Application for Planning Permission for Works or Extension to a Dwelling

Development: Single storey rear extension plus loft conversion including hip to gable and rear dormer.
Location: 8 Sefton Avenue Aldwick PO21 3BP

BLOCK PLAN 1:500 @ A3

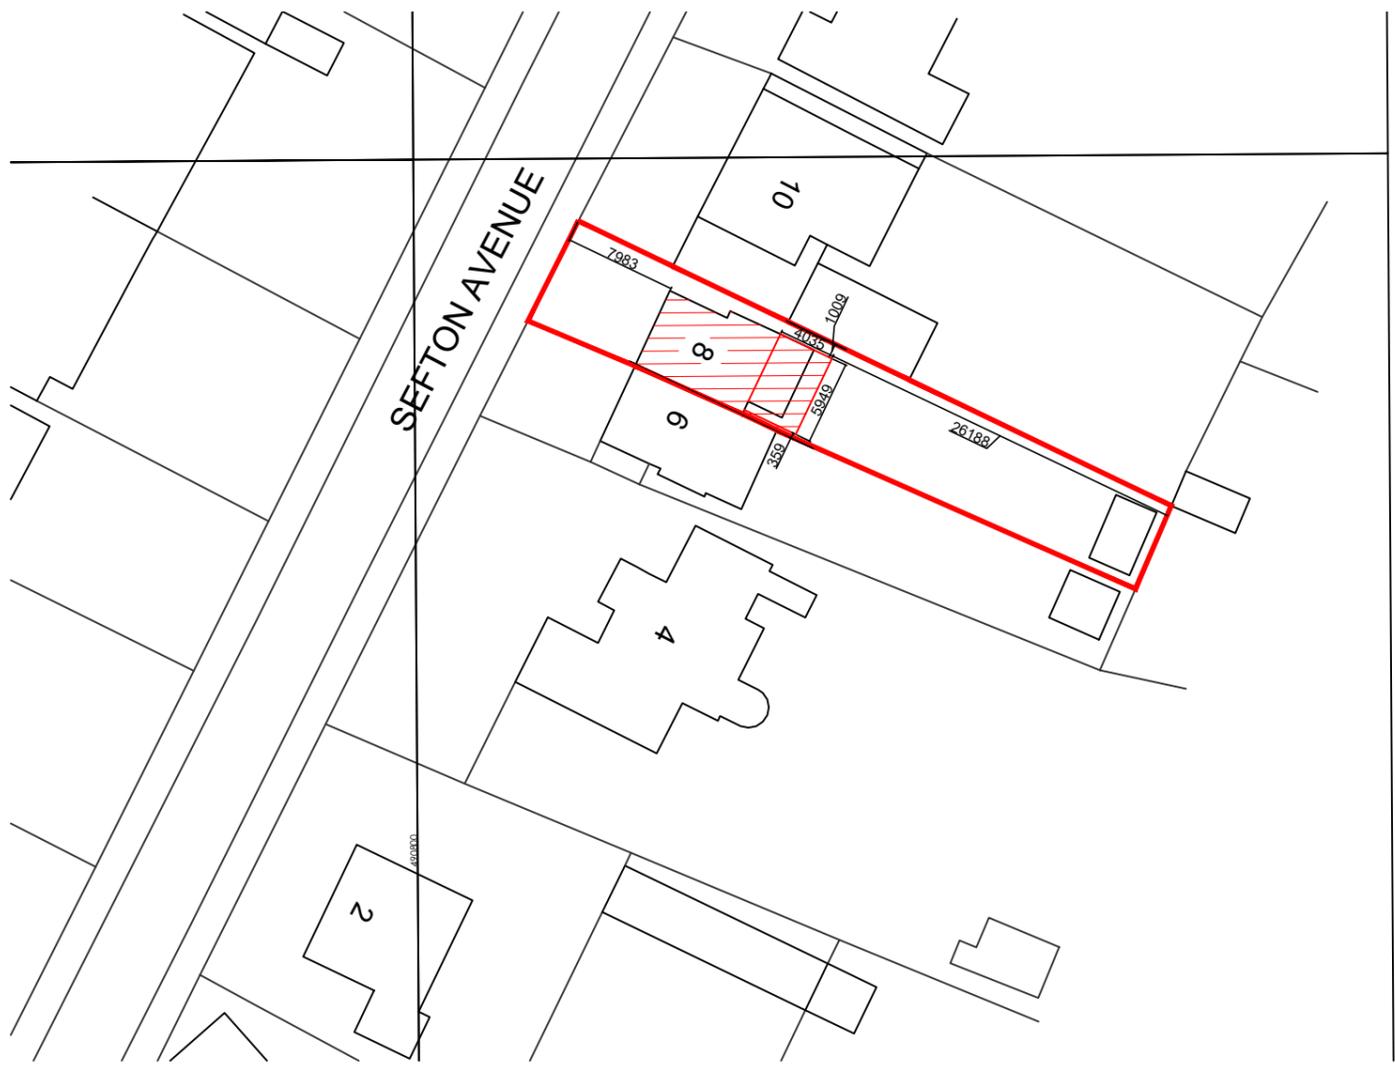
Block Plan

You are required to have dimensions from the proposed extension(s) to all site boundaries. The dimension to the rear boundary is missing, please amend.
